CITY OF ALBUQUERQUE

**Re: Plaza at San Mateo, Tract A Vidas Subdivision
2403 San Mateo, Grading and Drainage Plan
Engineer's Stamp Date 3/29/2013 (H17/D103)**

**GRADING PLAN**  
C201

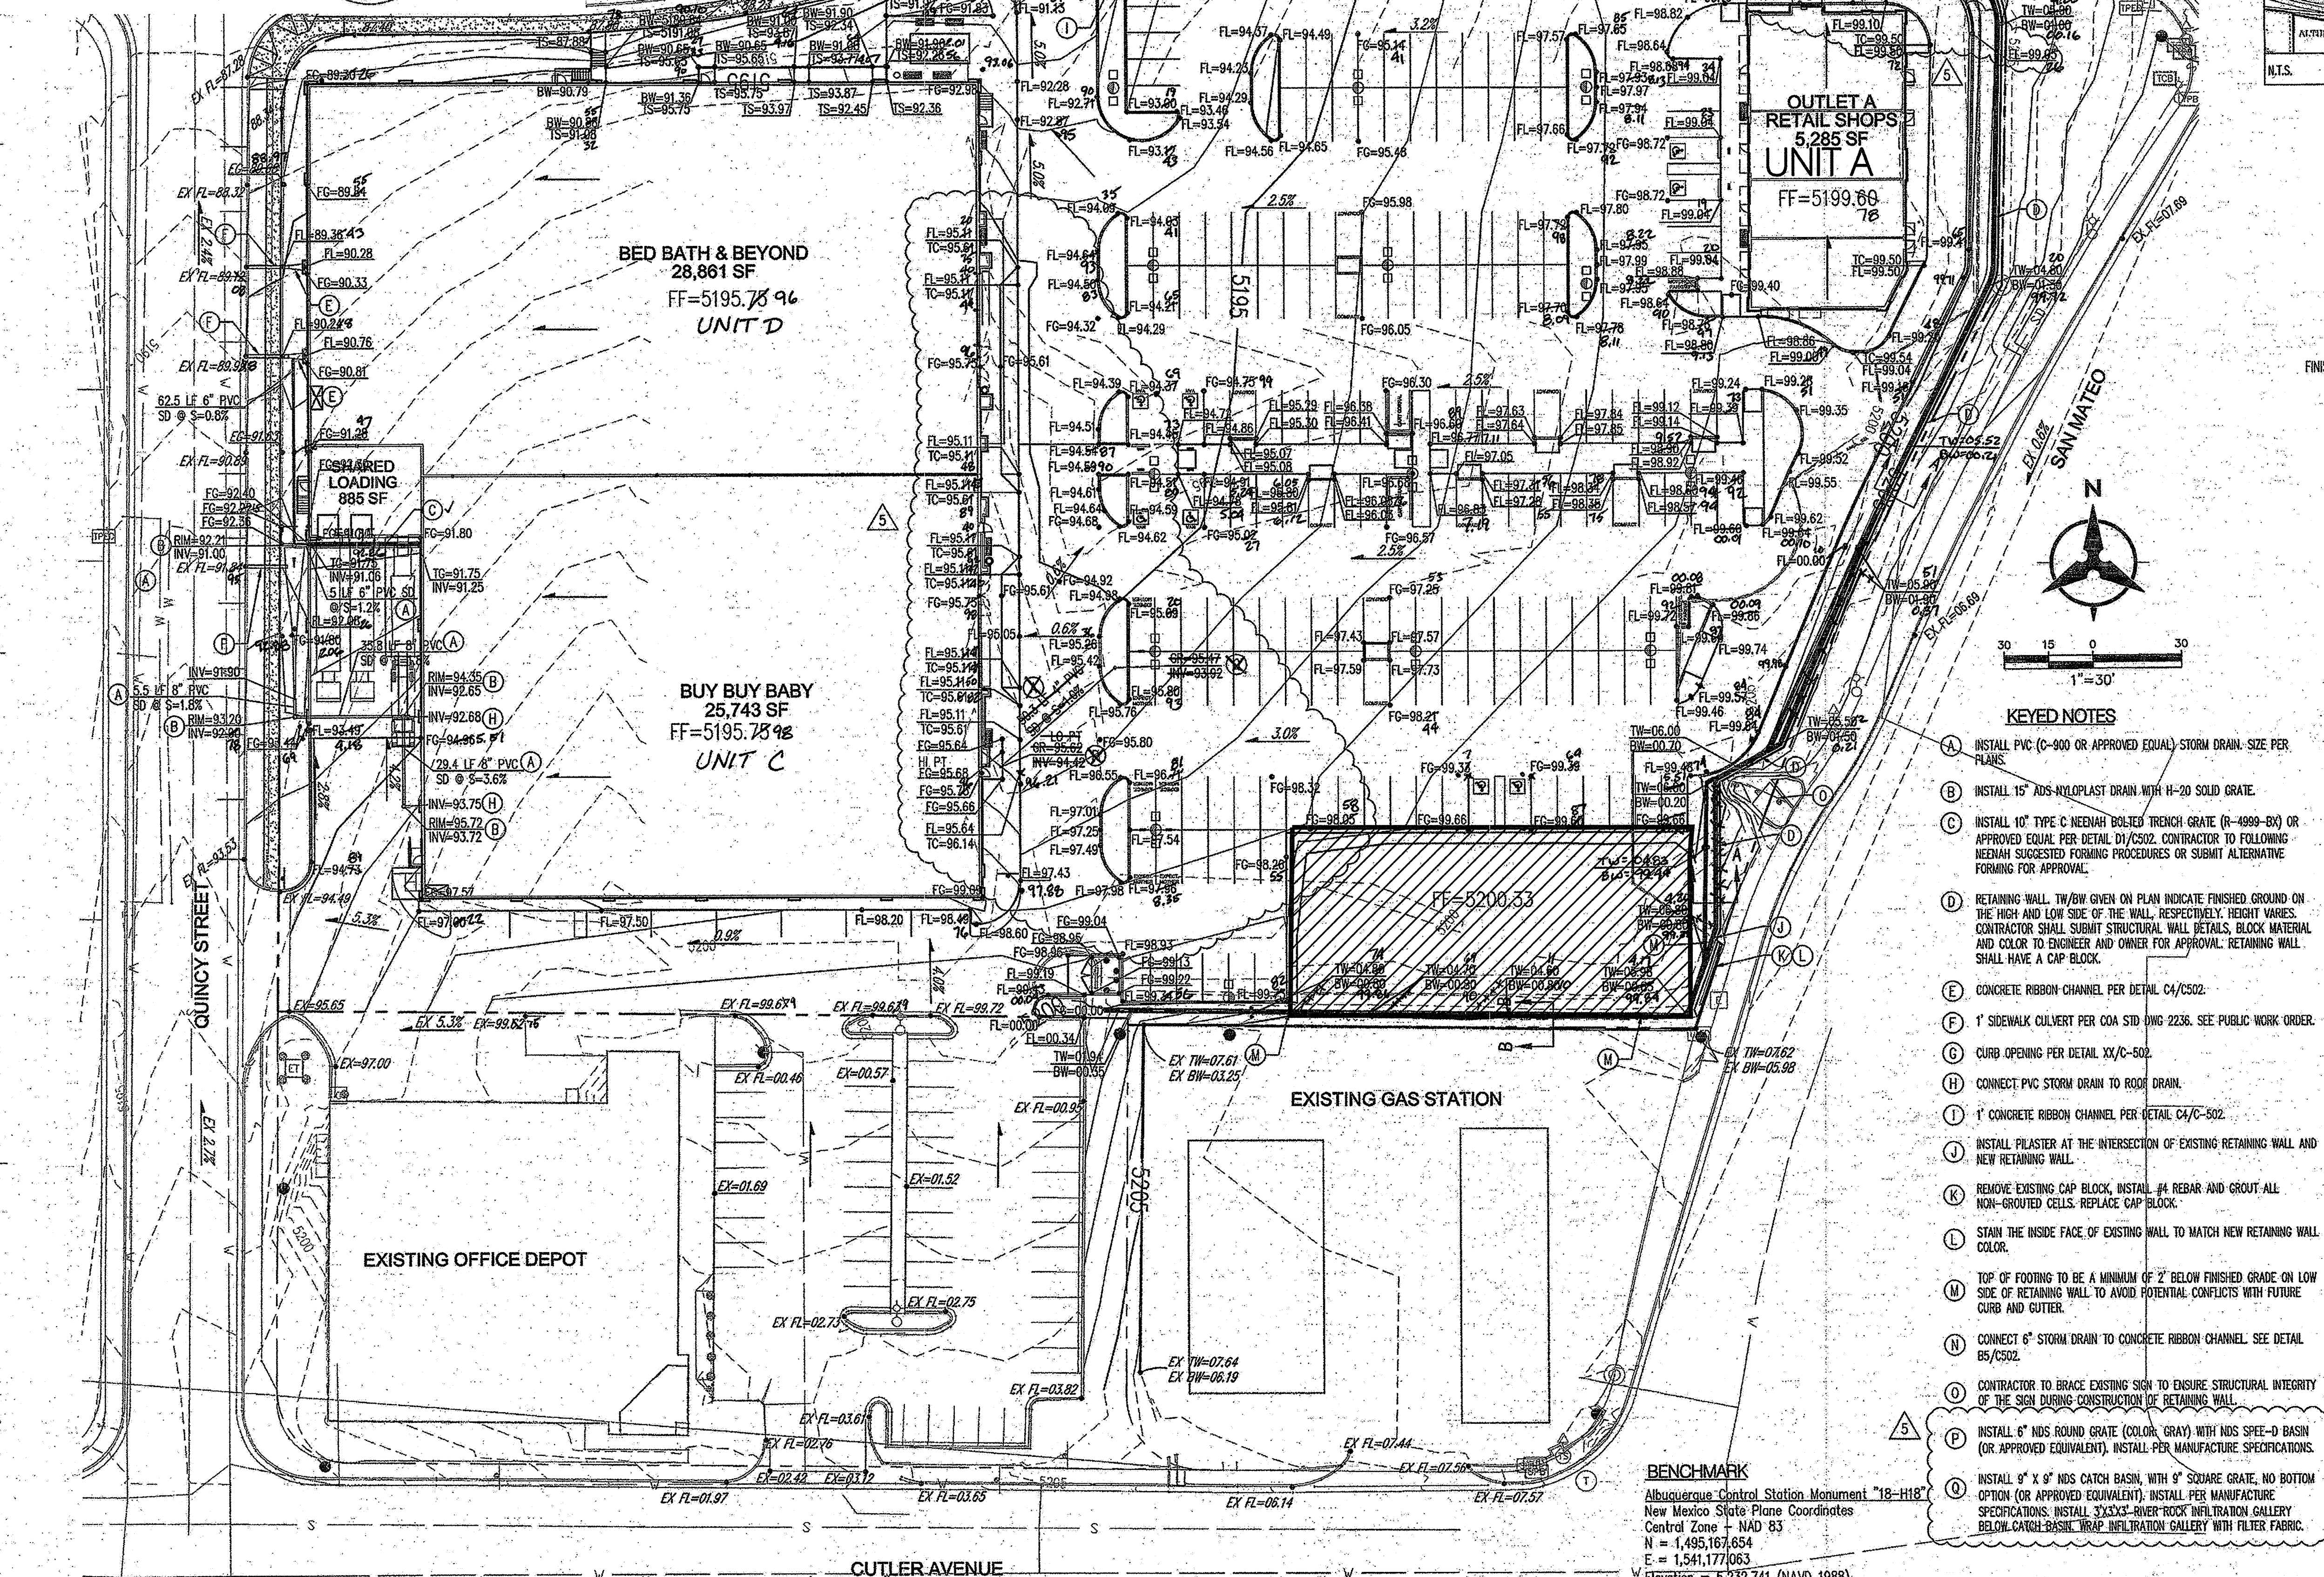
- The grading can not extend on the existing Gas Station. Proposed contours are shown on the west of existing station.
- Sidewalk culverts should be extended 2' passed the property line and the bolts to be tack welded to the plate. The sidewalk culverts will be constructed under the work order.
- This project requires an Erosion and Sediment Control Plan.
